S/AR/BR/2008/60

04/08/2008

Demolition of existing dwelling and erect 36no Sheltered Apartments & Communal facilities.

262 Hawthorn Road, Bognor Regis
BR/60/08

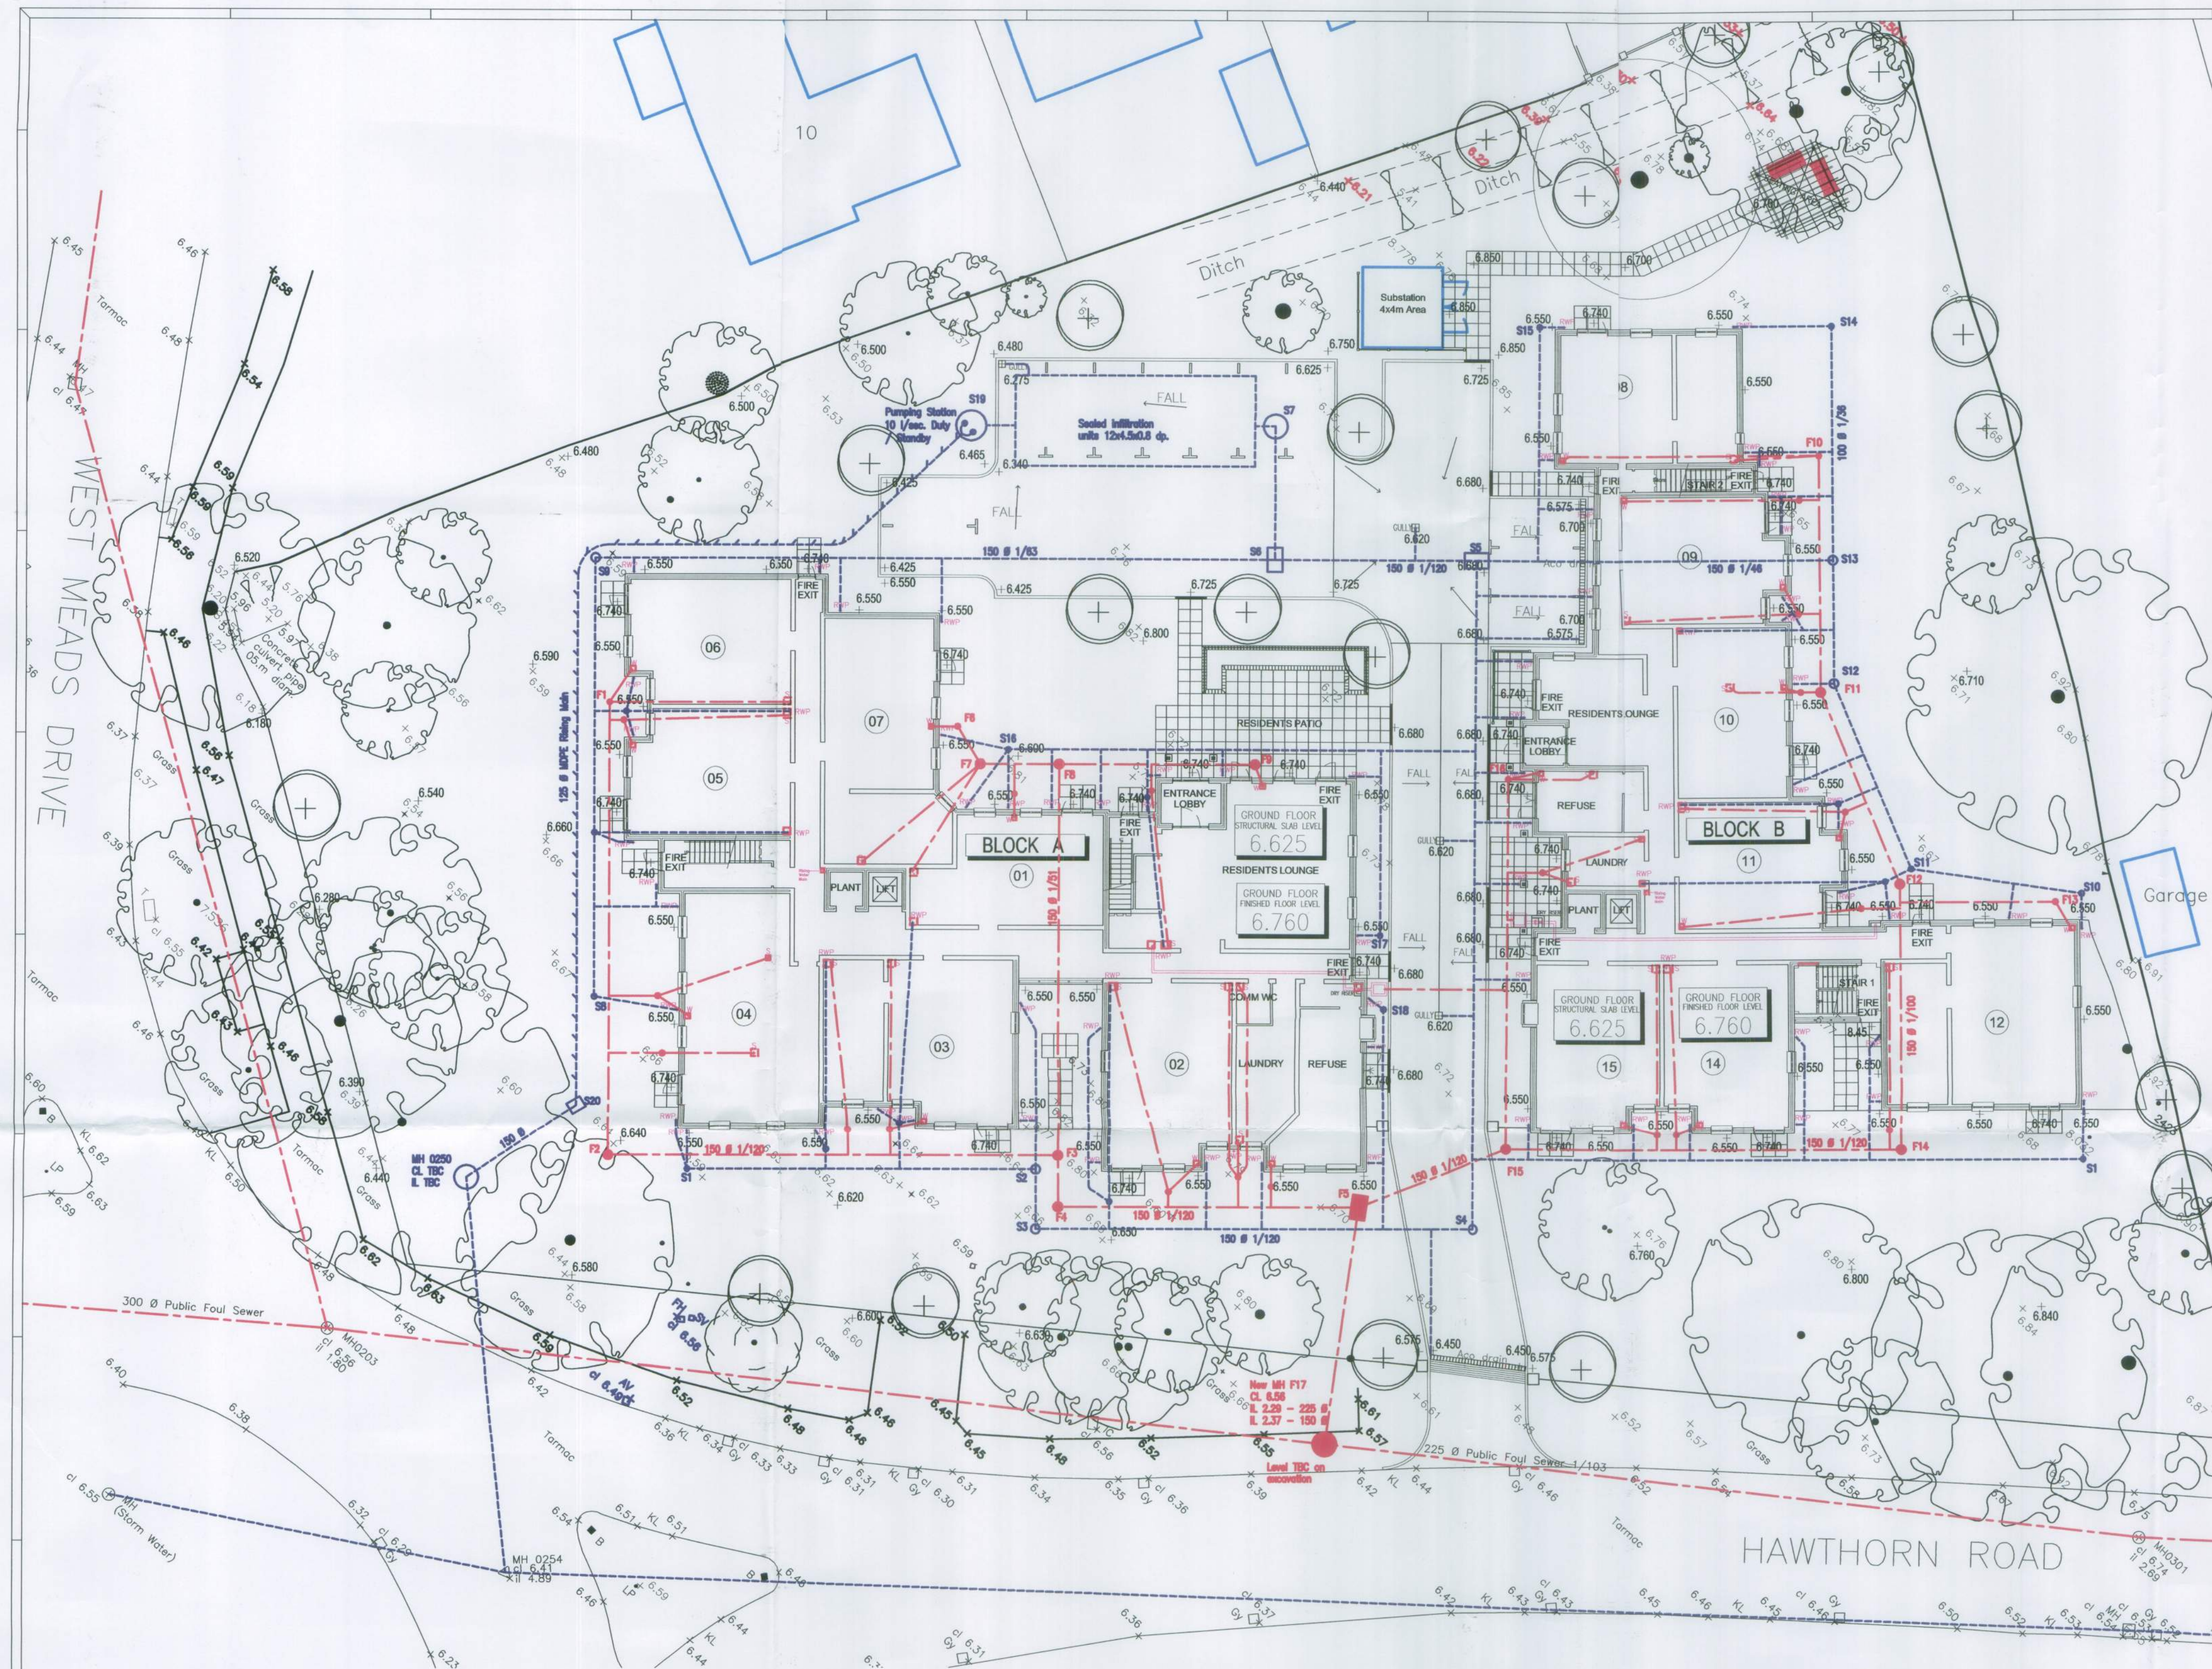
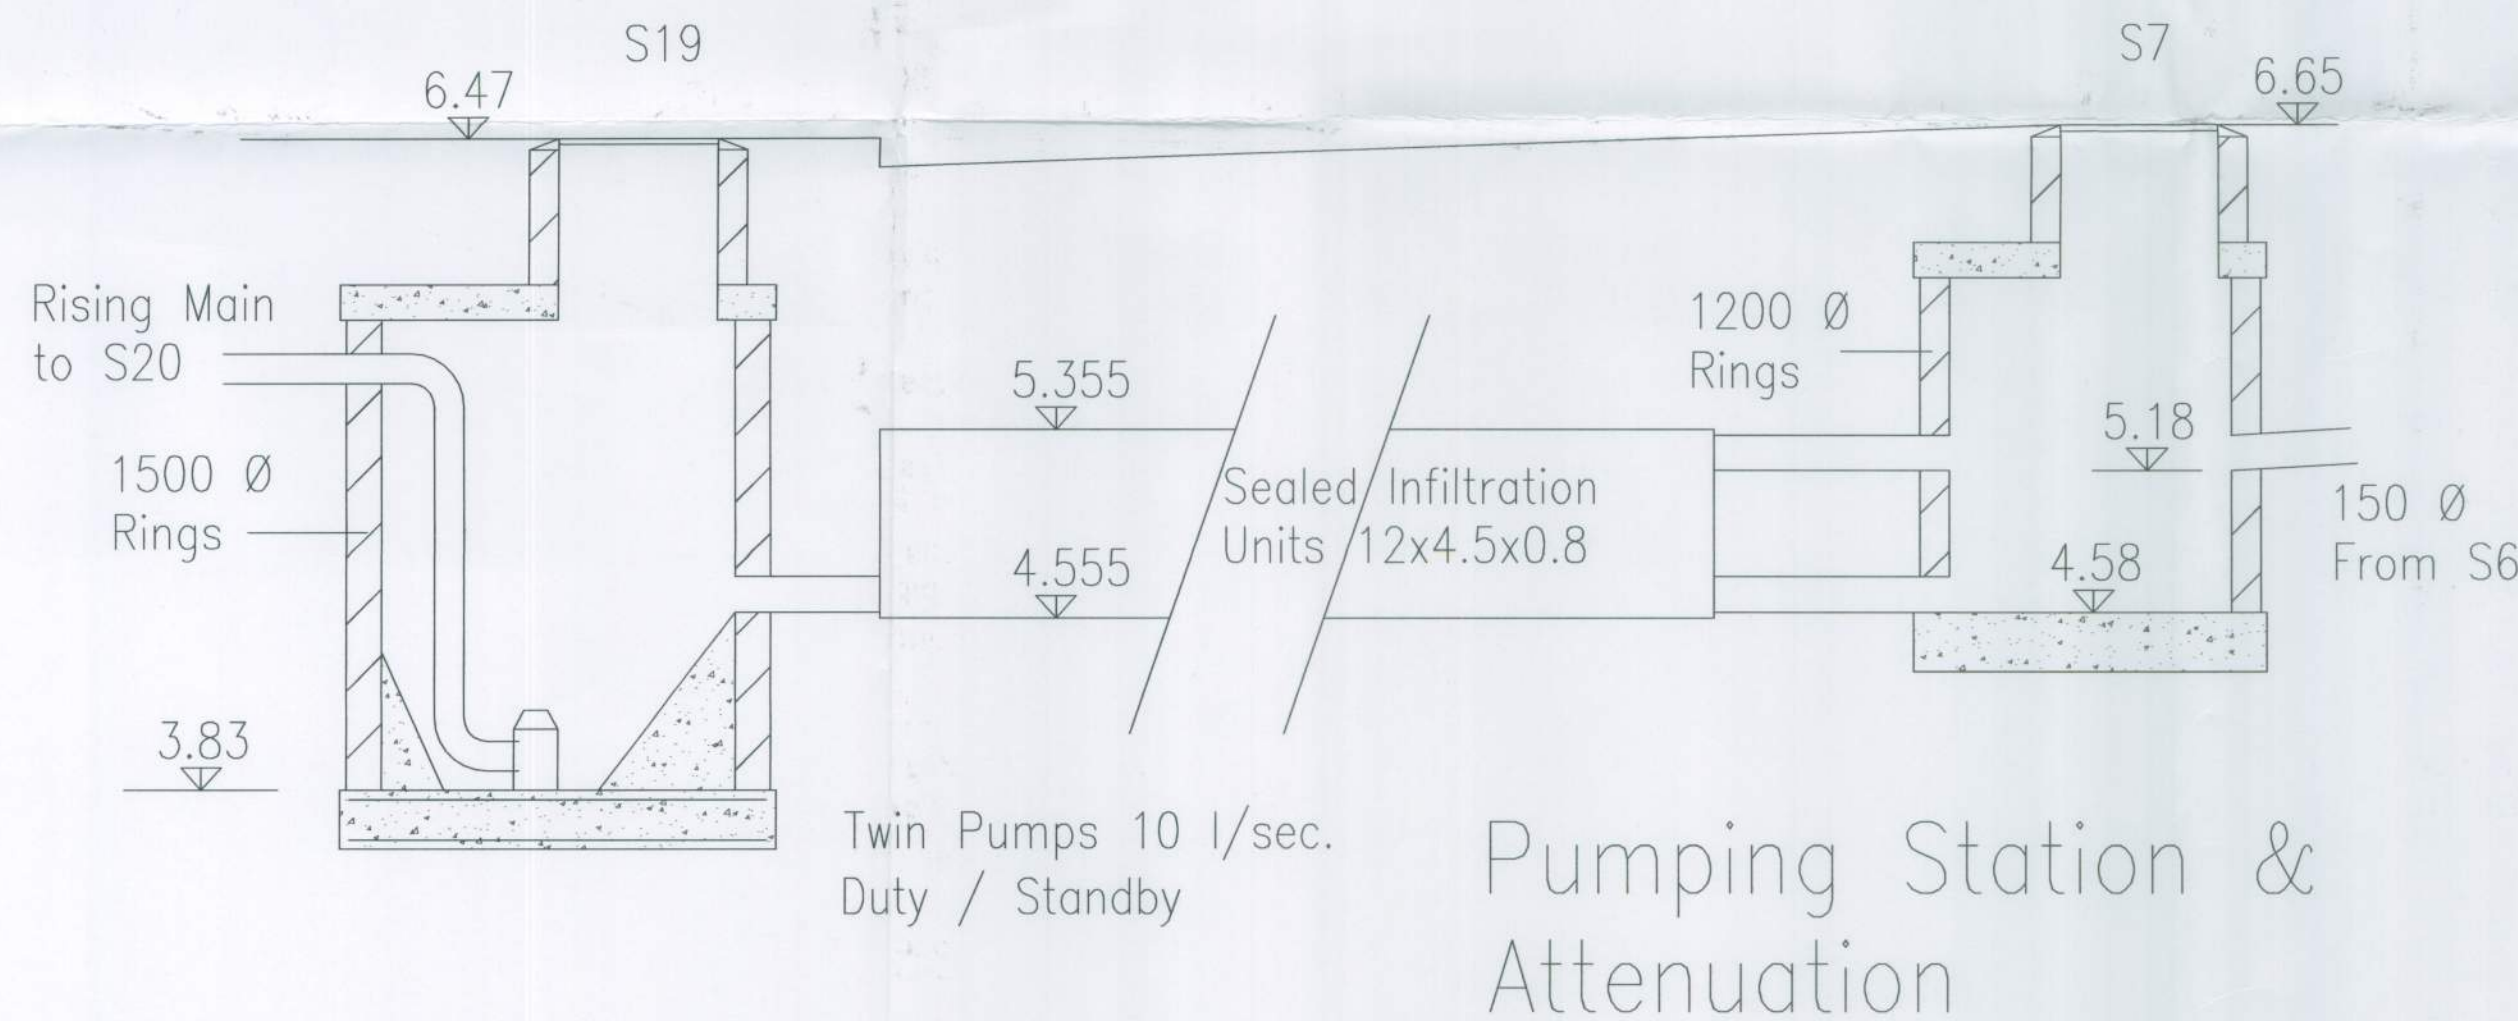
However, I regret that at this stage I cannot recommend approval of the proposed surface water details. There is insufficient spare capacity within the existing surface water sewer system to accommodate a pumped discharge of 10 l/sec from the proposed attenuation tank.

A pumped discharge equal to the peak runoff from the existing development would be acceptable. Southern Water would seek evidence of the connectivity of pre-existing drainage and calculations confirming that the proposed pumped surface water discharge will be no greater than existing in order to avoid flooding from the downstream sewerage system.

Alternatively, we advise that the applicant investigates alternative means of surface water disposal such as discharge to soakaways or an outfall to the nearby watercourse.
